Recommendation Report for Planning Permission for Works or Extension to a Dwelling

REF NO: AB/44/21/HH

LOCATION: Fern Cottage
5A Surrey Street
Arundel
BN18 9DT

PROPOSAL: Proposed loft conversion (This application may affect the setting of the Arundel Conservation Area).

Proposed Loft Conversion Plans and Elevations Planning
Date March 2021
Scale 1:50

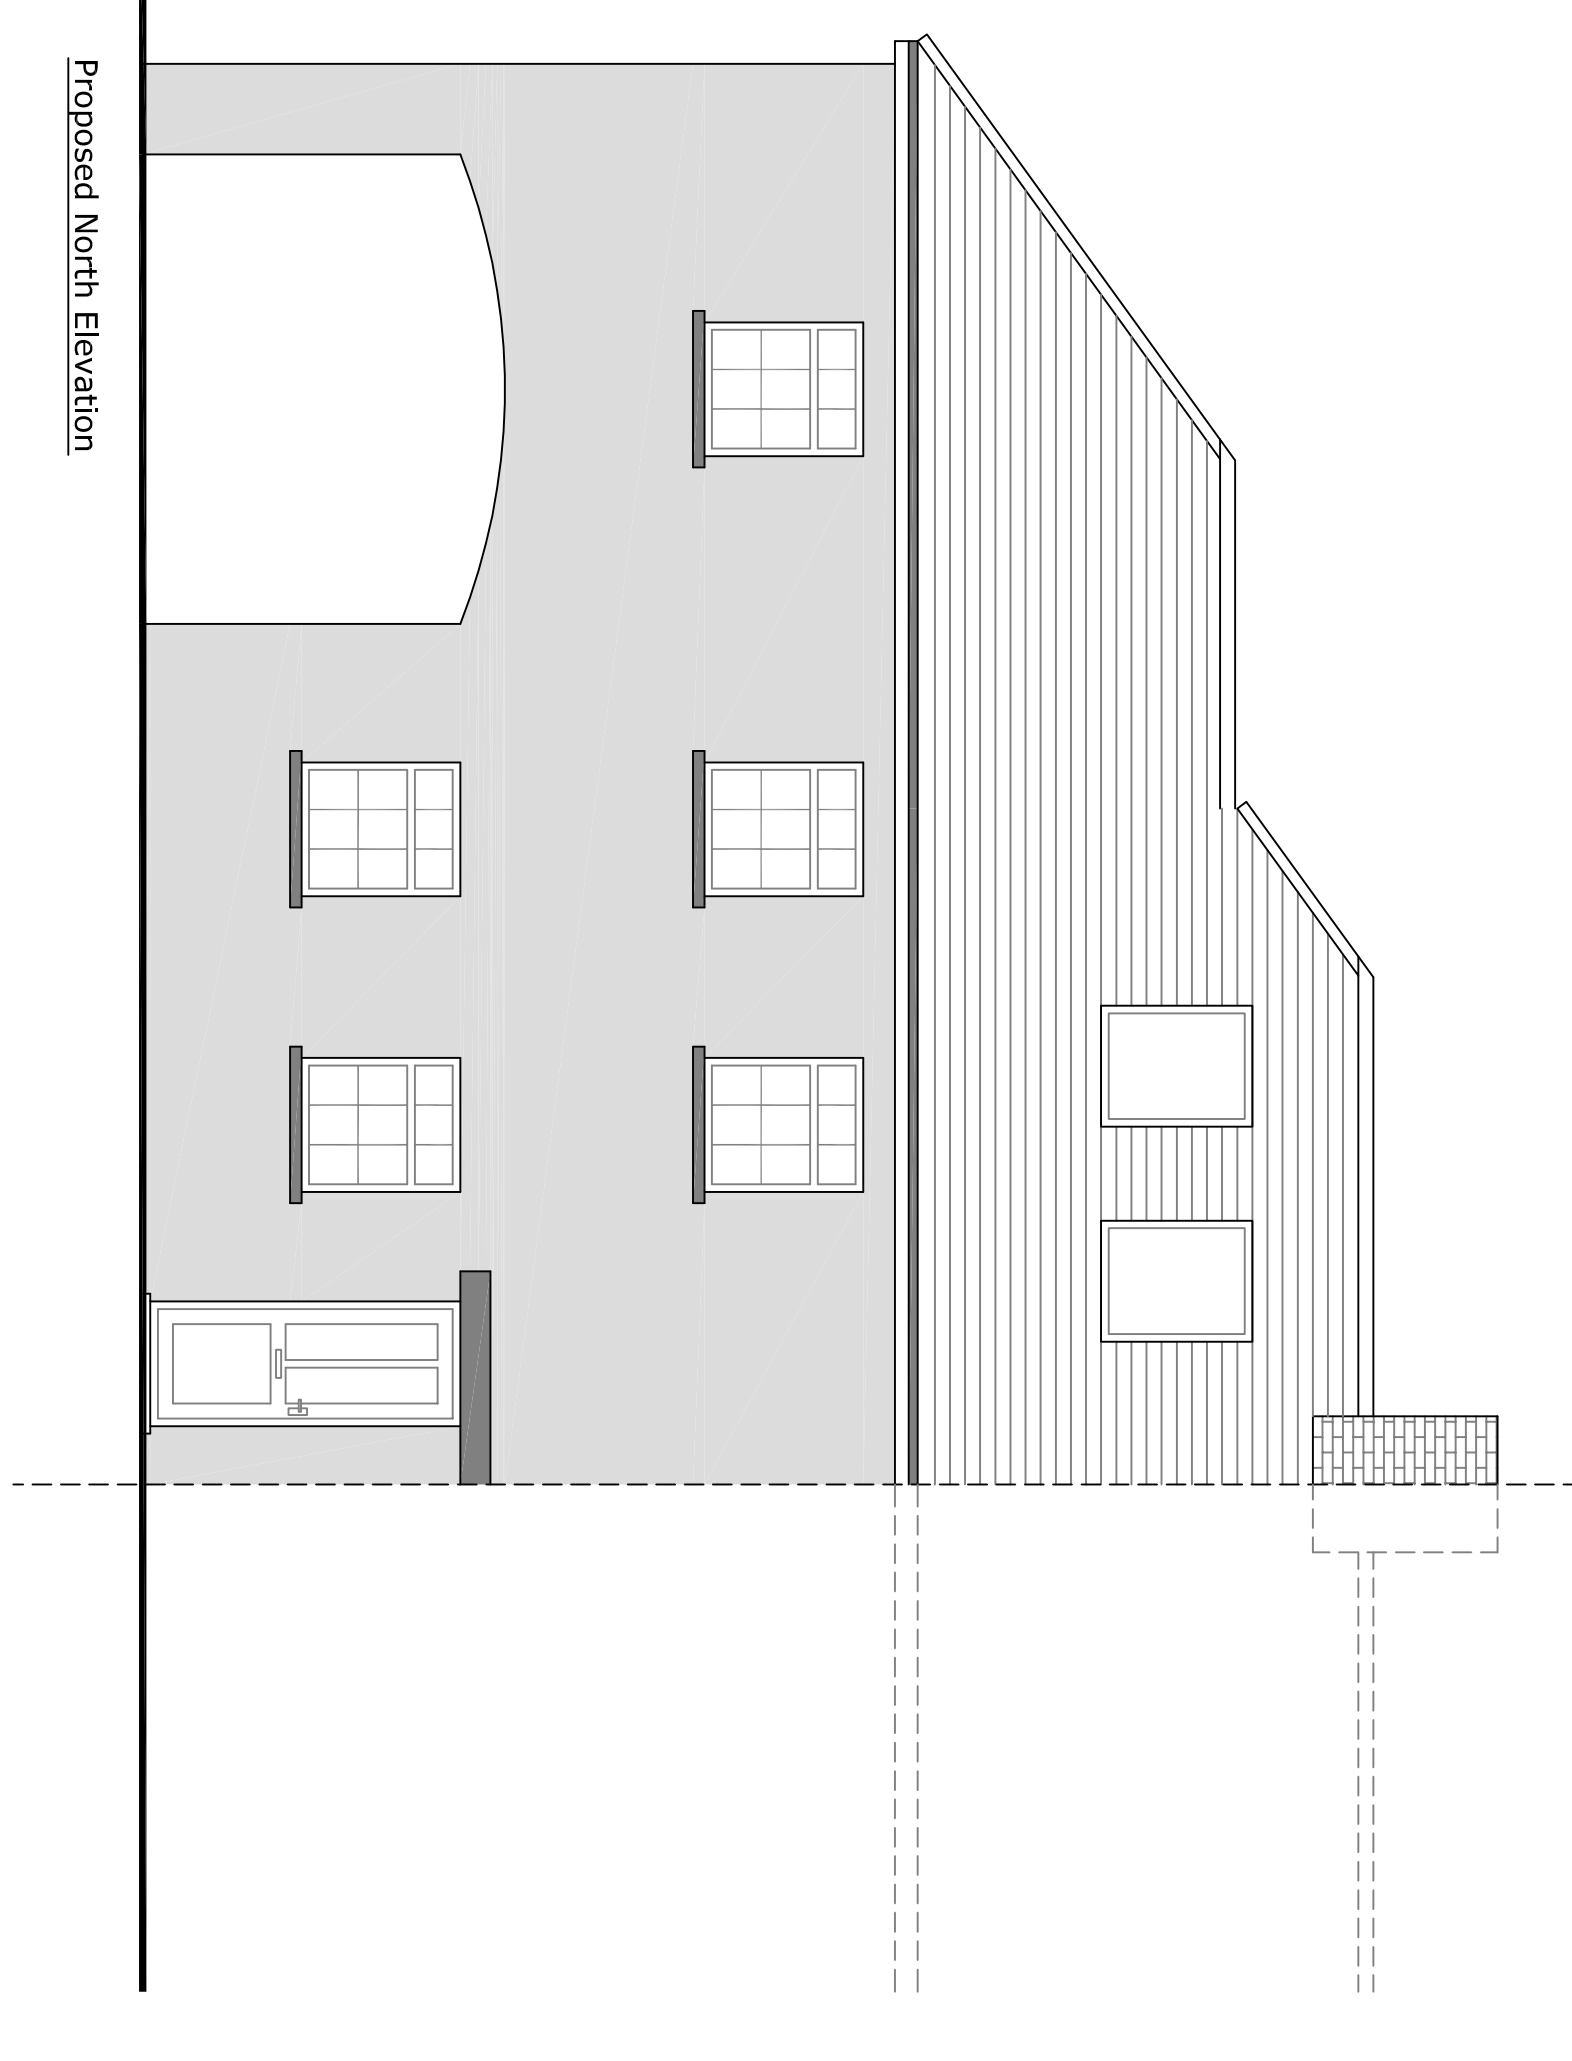
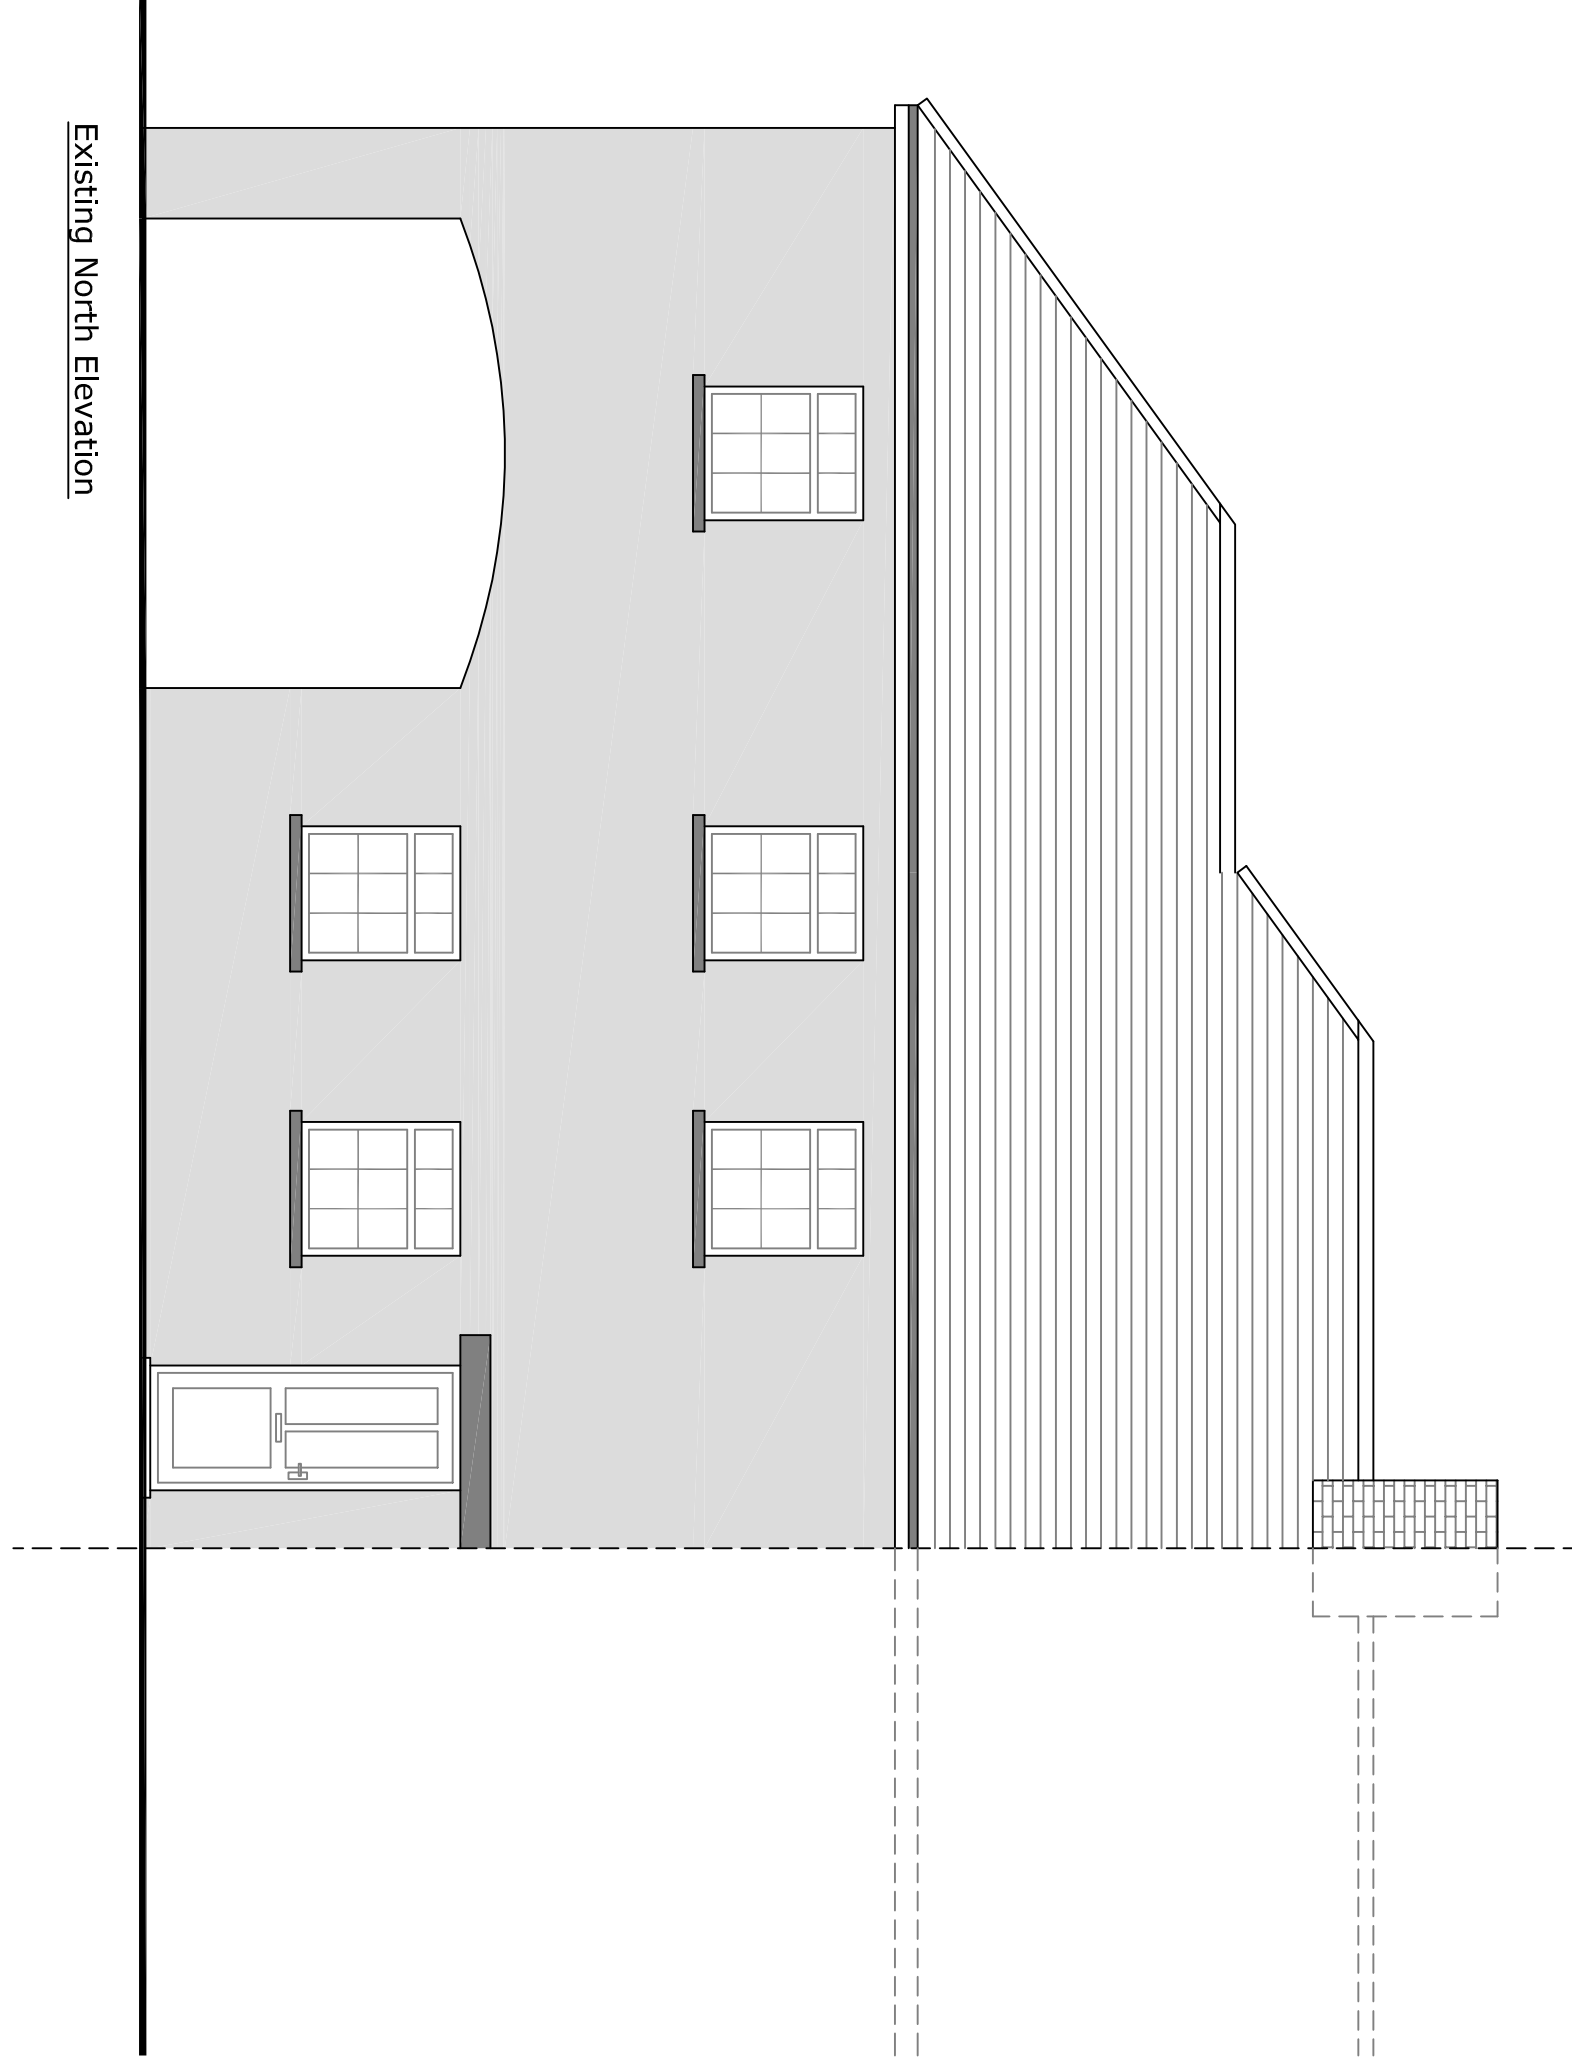
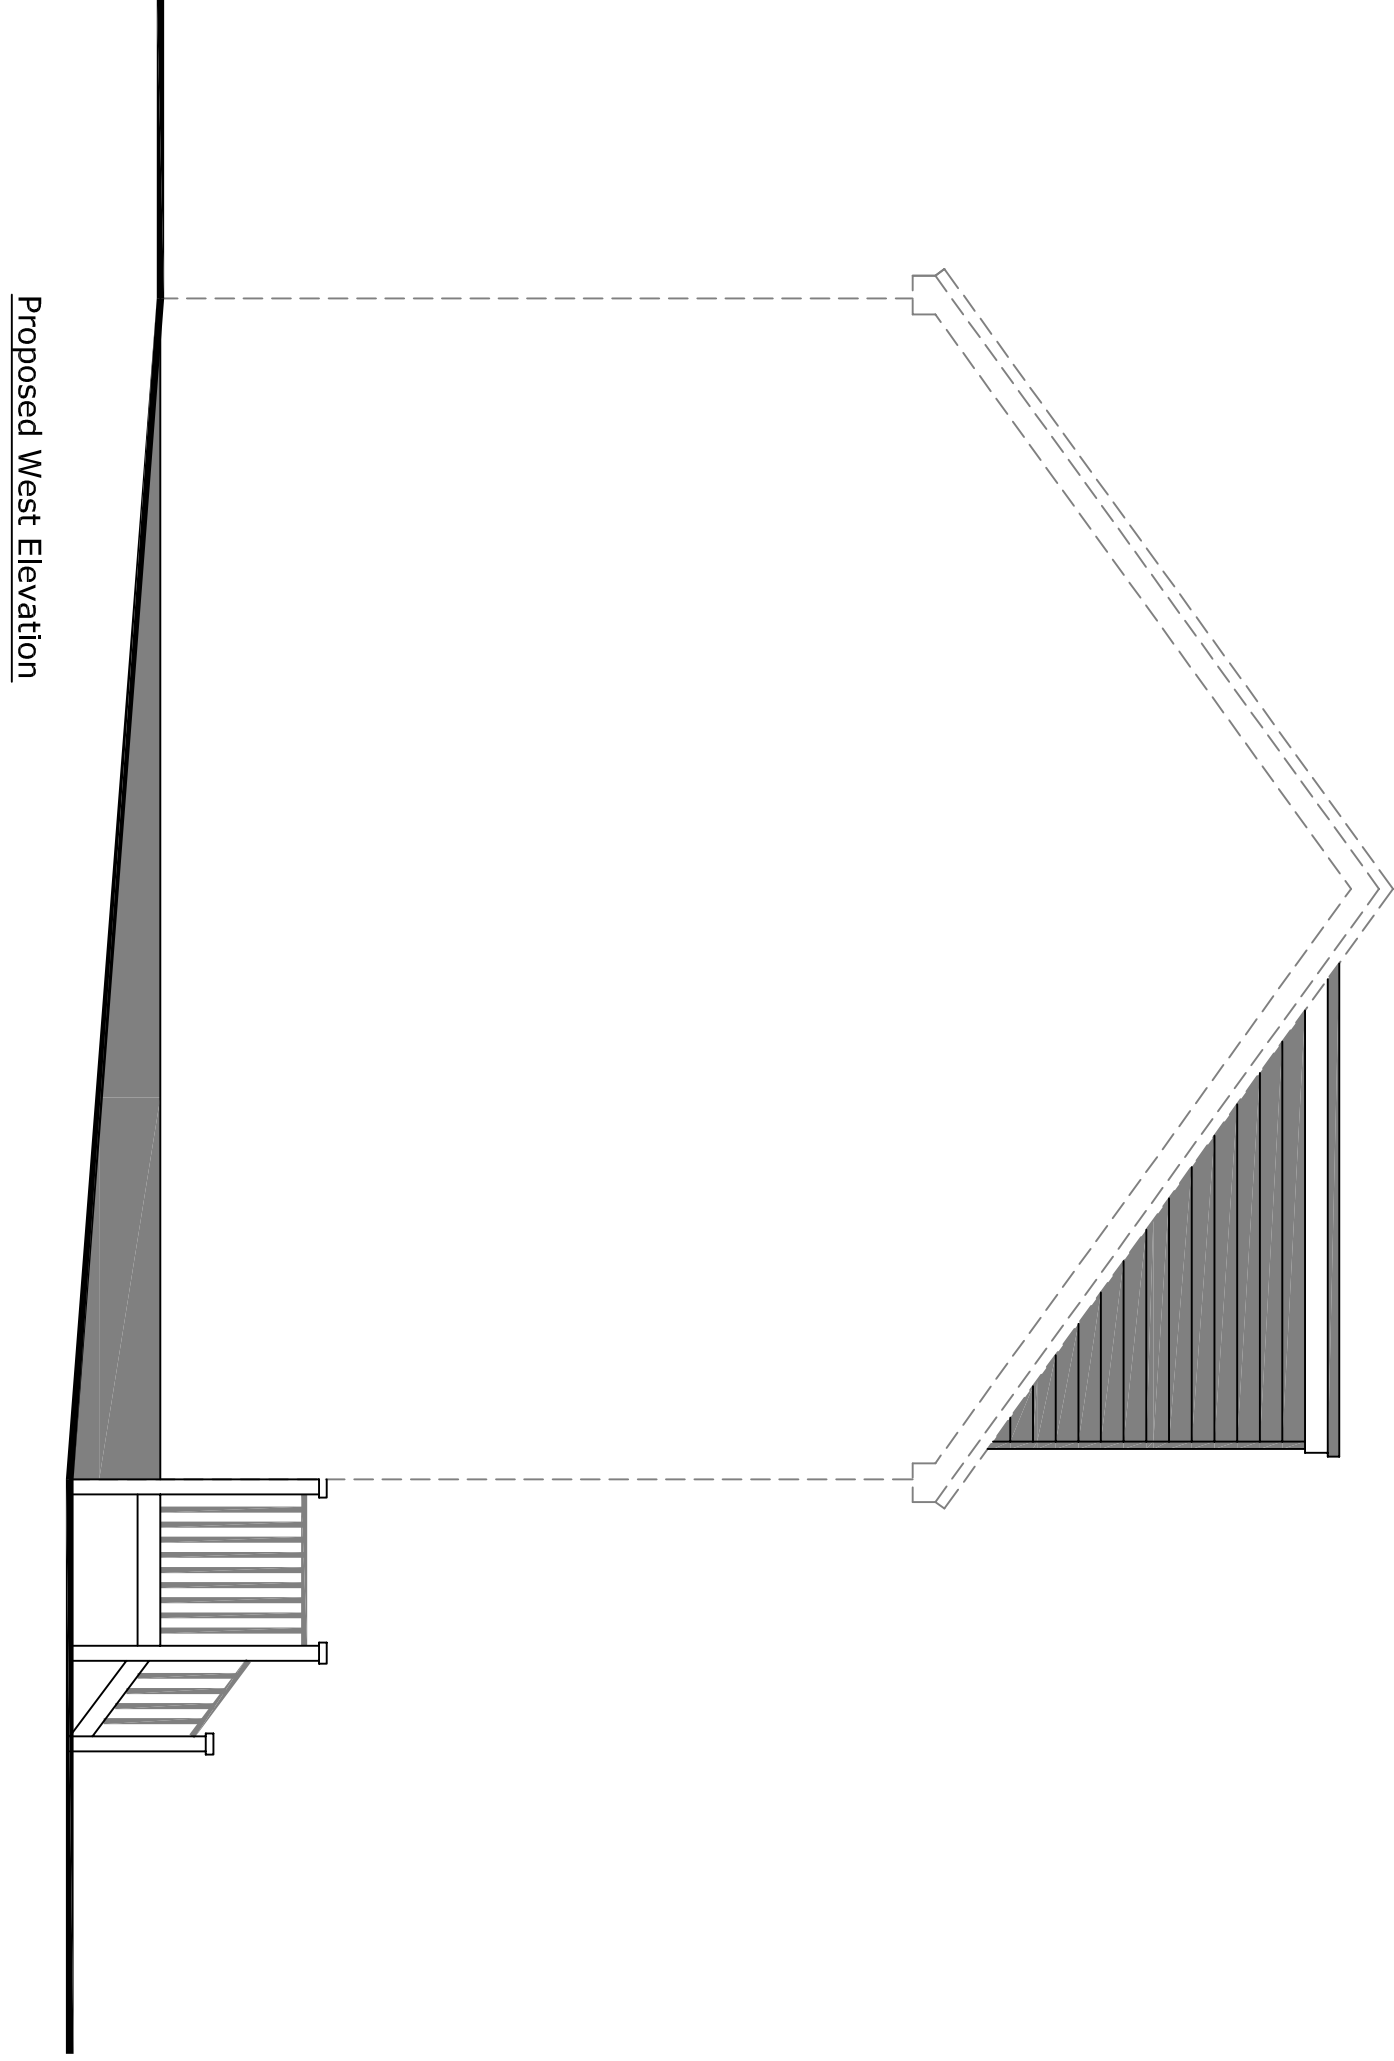
The proposal seeks to construct a rear box dormer to enable the conversion of the loft space within property, the application also seeks to install 2 roof lights to the front elevation. The resultant space will provide a new master bedroom and en-suite. To accommodate for the large dormer window the ridge of the main section of roof will be converted from a barn end to a gable, the ridge length will increase by approximately 1.1m. It is noted that there are inconsistency's in the plans as the proposed north elevation does not show this change and shows the retention of the barn end. It has also been brought to my attention that there are inconsistencies in the windowpane configuration of the elevations supplied.

Policy D DM4 of the Arun local plan requires proposals to be visually sympathetic and subservient to the character of the building and its locality. Although this building is not listed as it is of modern construction, it has been designed to mimic other buildings of significant character along Surrey Street, and it does form part of the Conservation Area. It is considered that the large box dormer is overly dominant on the building and out of character with other dormers in the area. Additionally, the application form refers to no materials being used in the external construction of the dormer, without the information relating to

materials it is impossible to comprehend if it would be visually sympathetic. However, its form and size and scale of features i.e. window, appears incongruent within the elevation, the large window on the upper floor appears top heavy.

From the street the proposal includes two large rooflights to the front elevation. The street scene forms an important feature of the conservation area, which is made up of, two-storey listed terrace cottages forming long uninterrupted roof sections. The rooflights will result in breaking up the roof plane and therefore detracting from the character of the conservation area and terrace of listed building to the west.

The property is situated within the Arundel Conservation Area. Its northern (front) elevation abuts the street. The dormer proposed to the rear of the property can not be seen from the front however in order to accommodate the dormer the main ridge line must be changed from a barn-end to a gable, lengthening the ridge in the process. The property is part of a semidetached building. Both the existing eastern and western elevation have this barn-end therefore the alteration of one, will in effect unbalance the look of the building.

More significantly to the Conservation Area is the insertion of two large roof lights to the northern elevation. The roof lights will have the effect of breaking up the uninterrupted roof plane running along the street and detract from the character of the conservation area and negatively impact the listed buildings to the west.

Paragraph 190 of the NPPF requires the council to consider the significance of the impact on the asset. The box dormer to the rear has minimal effect on the street scene, however the roof lights to the front will negatively impact the uninterrupted roof plane, at a minimum conservation roof lights would have been more appropriate.
